17 March 2015
Our Ref: 6131N.30ER

**Section 75W modification of Project Approval issued for MP09_0180
34-36 Memorial Avenue, Kellyville
Modification of Clusters 1 and 5**

On 15 December 2014, DFP Planning lodged an application under the now repealed Section 75W of the Environmental Planning and Assessment Act 1979 (EP&A Act) to modify the Project Approval issued in relation to MP09_0180 as it relates to Clusters 1 and 5 of the approved development. This application was lodged on behalf of BaptistCare NSW and ACT being the proponent and owner of the development.

536C5_ DA_ 75W_ 3.15 **D**

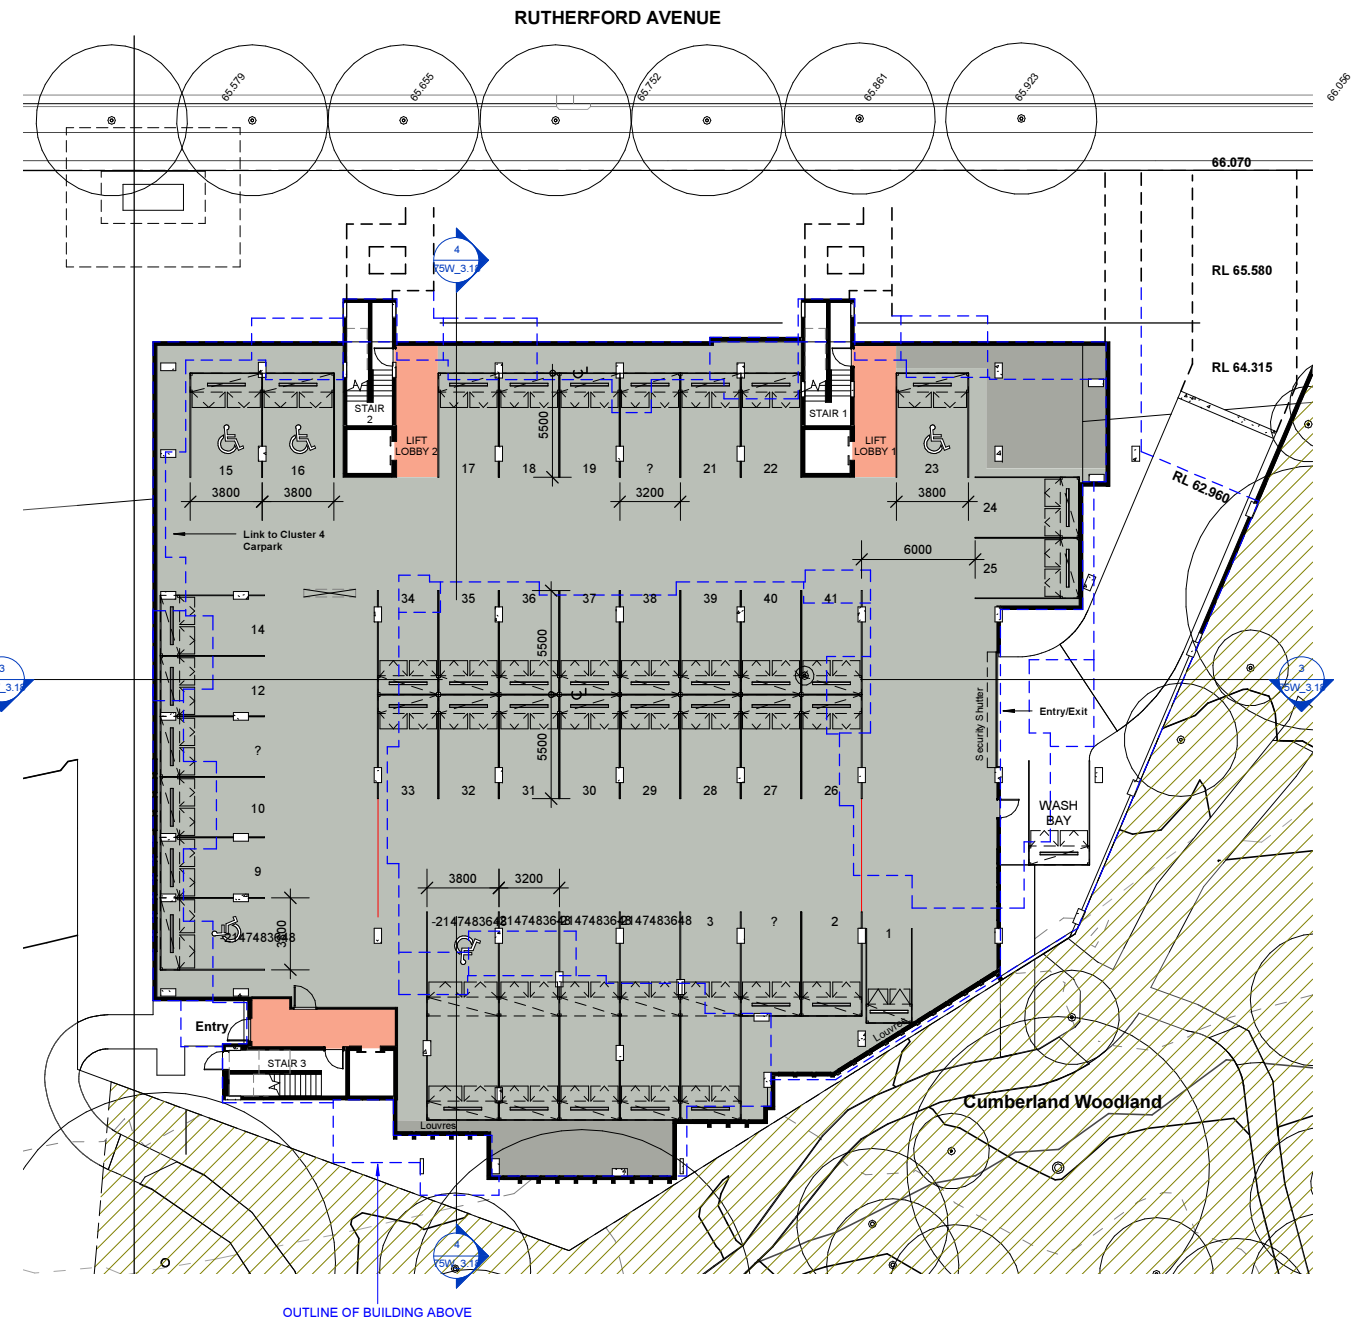
- A redesign of the basement level to reduce the size of the basement footprint. The car parking layout has been modified however a total of 41 car parking spaces will continue to be provided. The number of car parking spaces which are 3.8m wide (to comply with the provisions of Item 5 of Schedule 3 of SEPP Seniors) has been reduced from 7¹ (as shown on the plans submitted on 15 December 2014) to 5 however, overall, the number of 3.8m wide spaces for the entire development will exceed the minimum requirement of 46 spaces.

In relation to Point 3 of the submission made by THSC, all car parking spaces within the parking level have been dimensioned and all spaces are a minimum of 5.5m in length.

C5 South Elevation

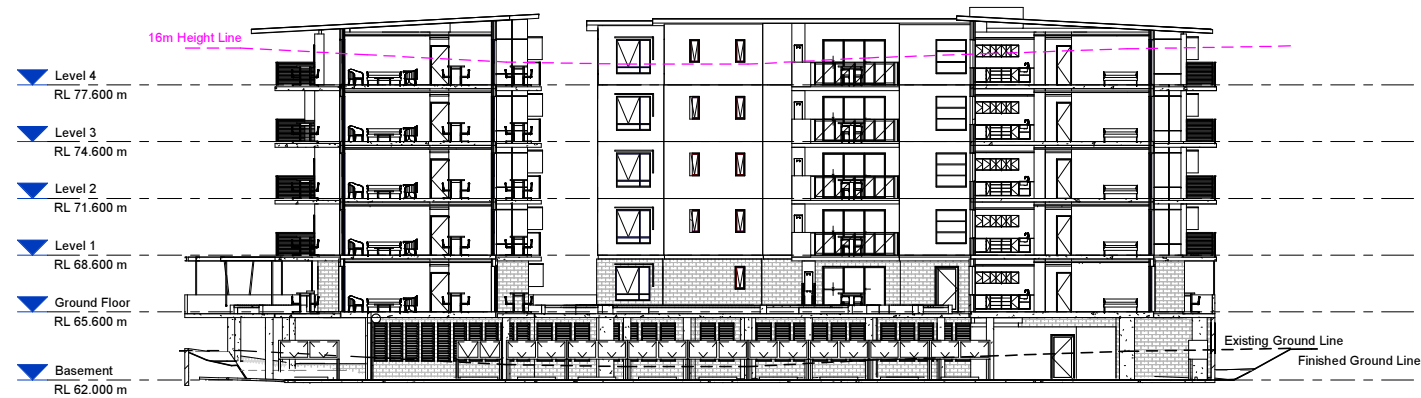
- Overall the building has been reduced in size and height.

The reduction in the overall height of the building is also seen as a positive. Notwithstanding that the building will still be more than the 16m height limit permitted by The Hills LEP 2012, the extent of non-compliance is less than previously considered by The Hills Shire Council and less than that of the exhibited modification proposal.

Drawing:
Typical Floor Plan Level 1-4 - Cluster 5

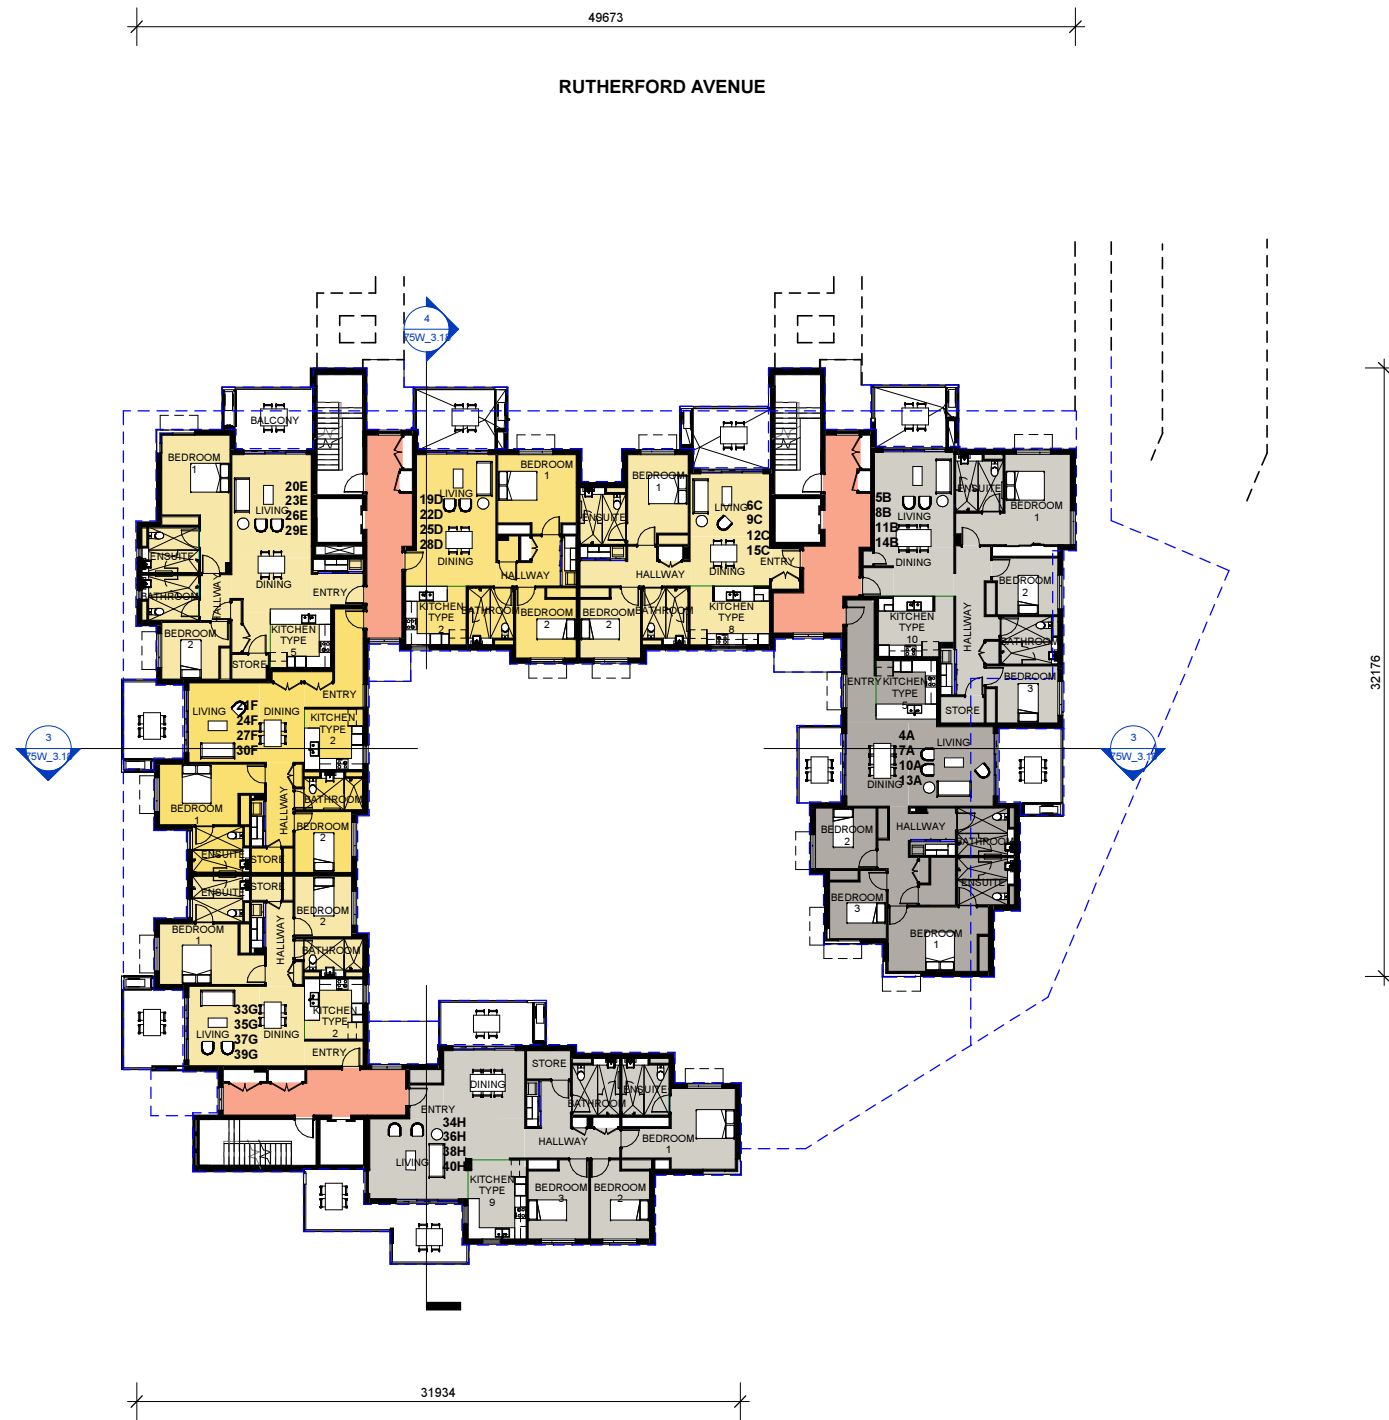
- The layout and floor plans of the apartments have been varied slightly to make more efficient use of space. The number of apartments proposed will be the same – (40) but the total amount of floor space per level will reduce from 980sqm to 897sqm – a reduction of 83sqm per level. This has been achieved through some internal reconfiguration of rooms and variations to the building footprint.

The most significant change has been in relation to new Apartment Type H (previously identified as Apartment Type G). The revision provides for an extension of this 'wing' of Cluster 5 building to the south however the building will not encroach beyond the boundary of the area identified as the Cumberland Plain Woodland reserve in the Section 88B restriction as to user that applies to the site and the development.

- On the upper levels, balconies have been enlarged and lengthened where possible to provide additional private open space.

An additional balcony has been provided to the northern elevation of Apartment Type A to improve solar access to the private open space of this apartment type. An additional balcony has been added to the eastern side of Apartment Type H to increase the private open space provision to this apartment type.
